MECKLENBURG COUNTY
Park and Recreation Department

MEMORANDUM

DATE: February 17, 2023

RE: Rezoning Petition #2022-160
PID# 05302210, 11, 12, 19, 20, 21, 25

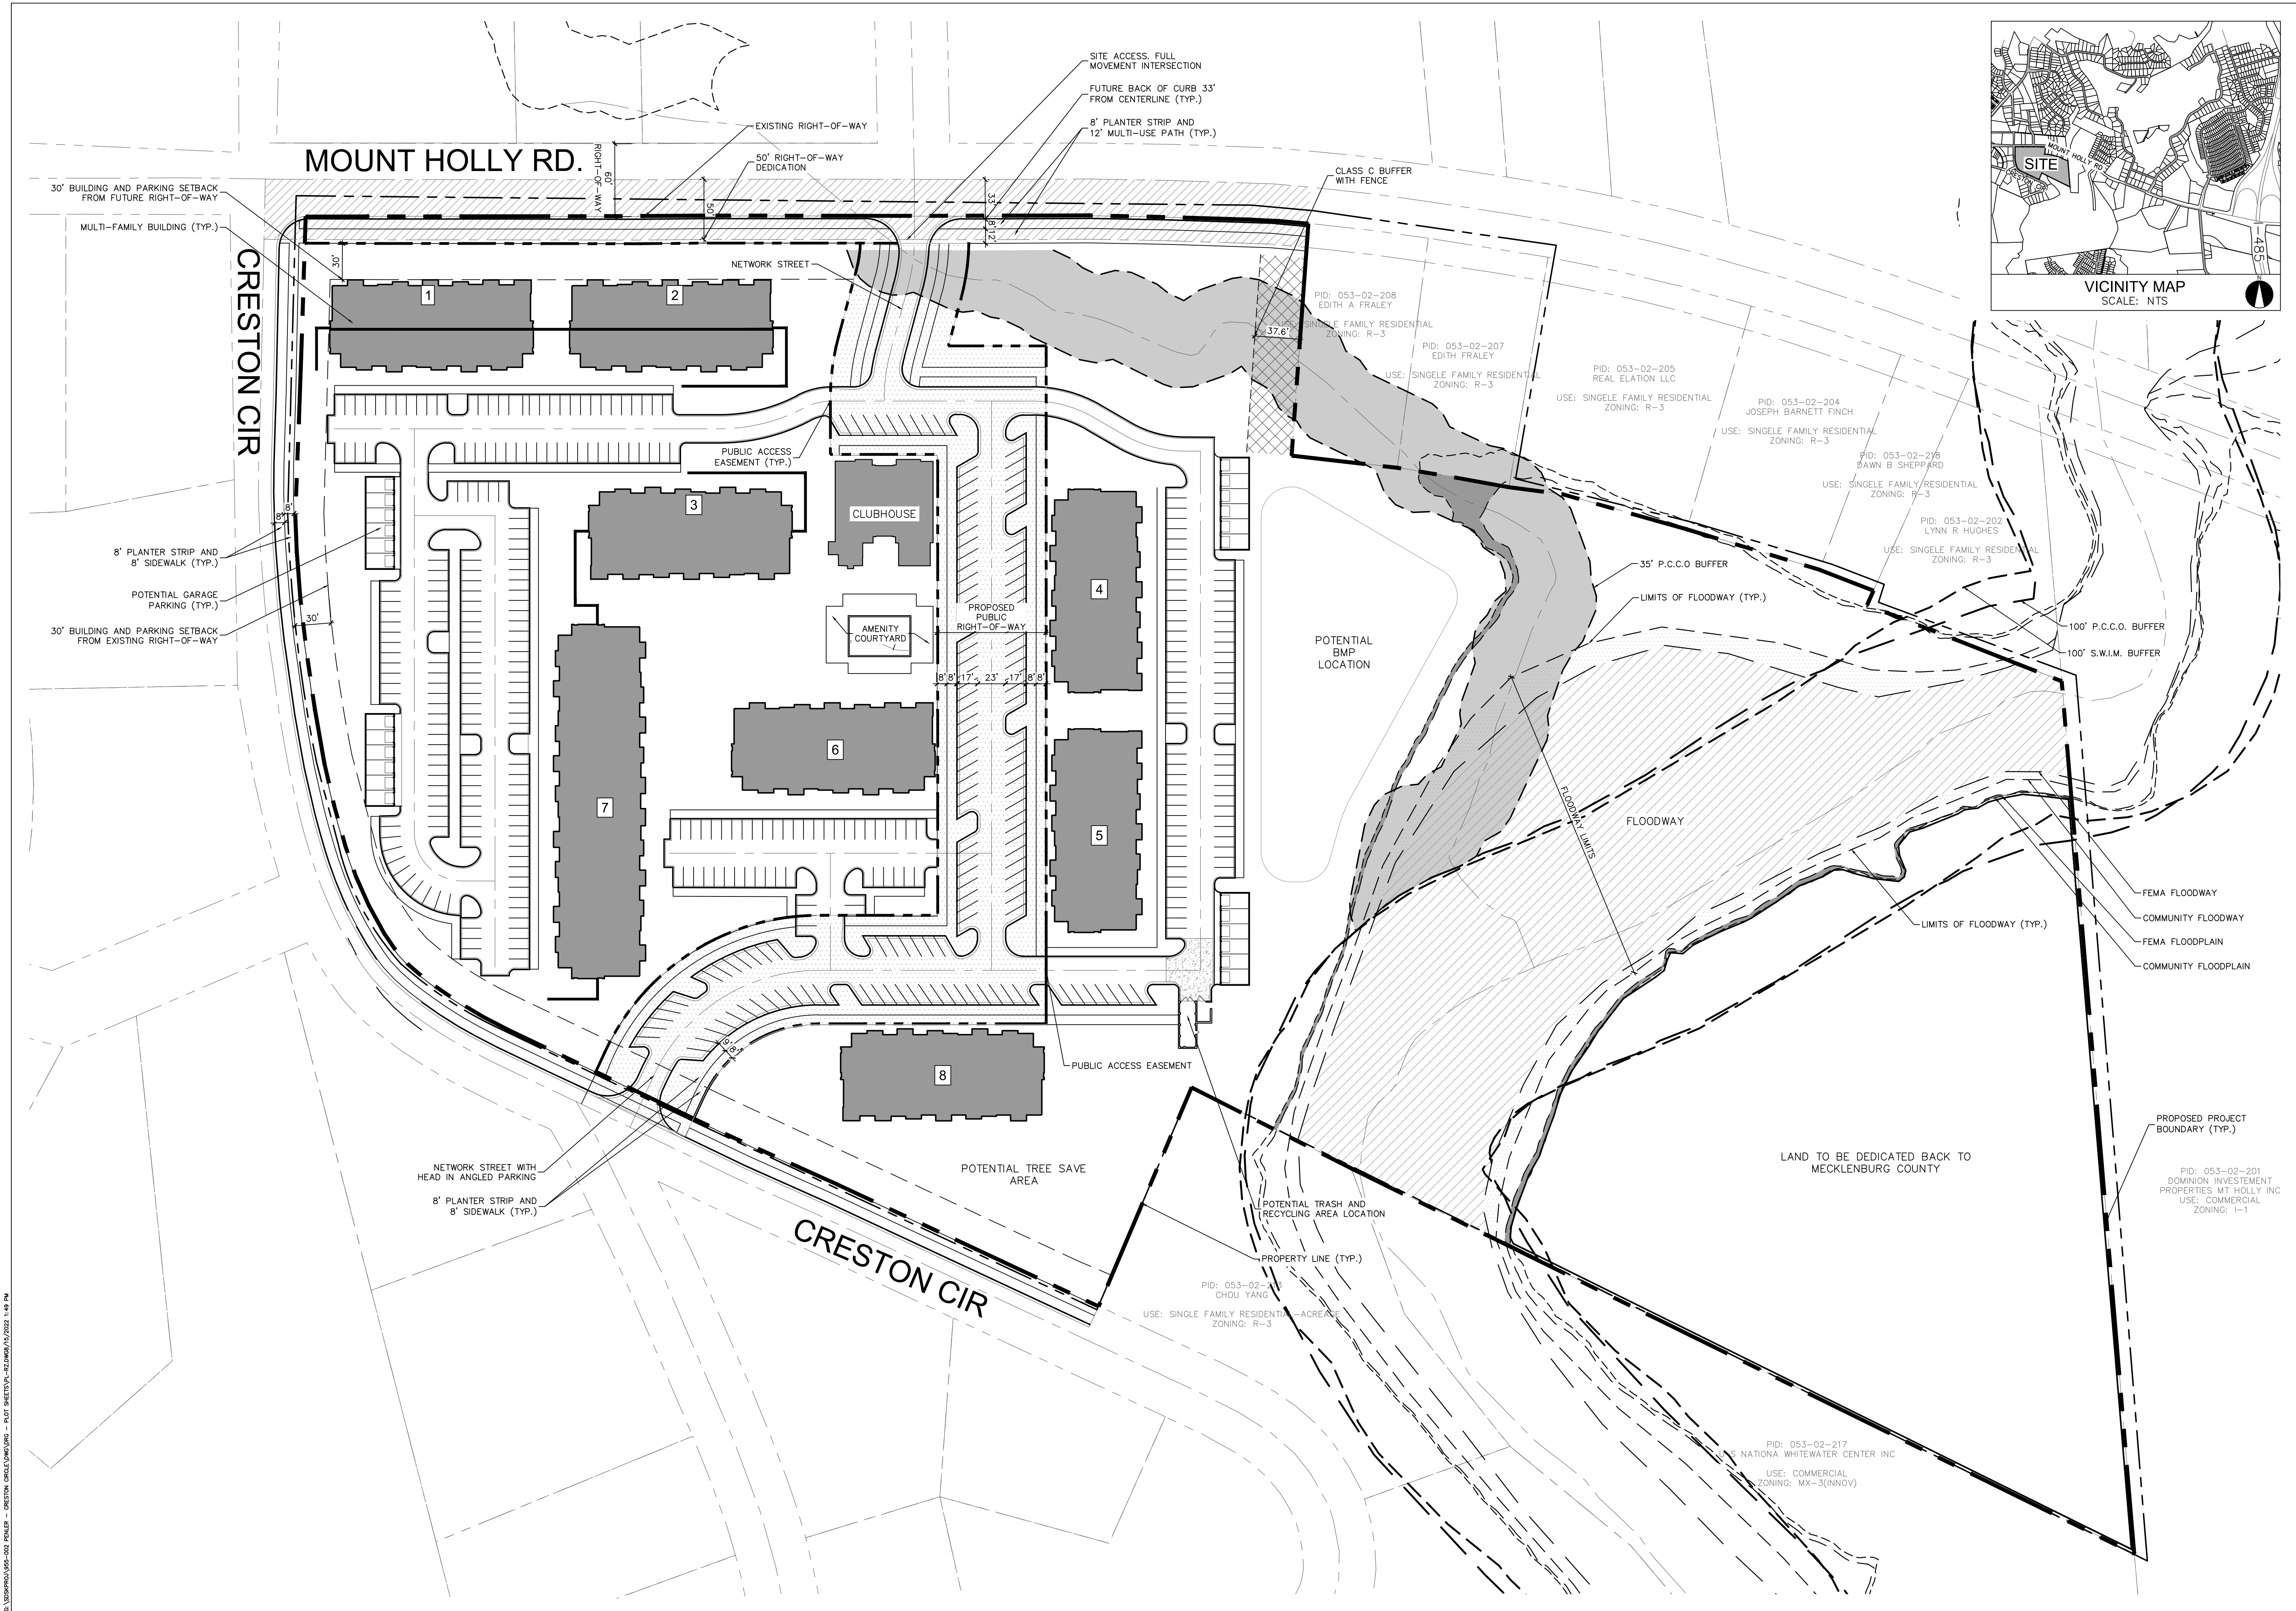
Plans show an area to be dedicated to Mecklenburg County. MCPR requests that the dedication area include the 100' SWIM buffer on both sides of Long Creek as well as a minimum 60' wide access easement between the public street ROW and the greenway trail dedication area. The note should read that the area is to be "dedicated and conveyed to Mecklenburg County."
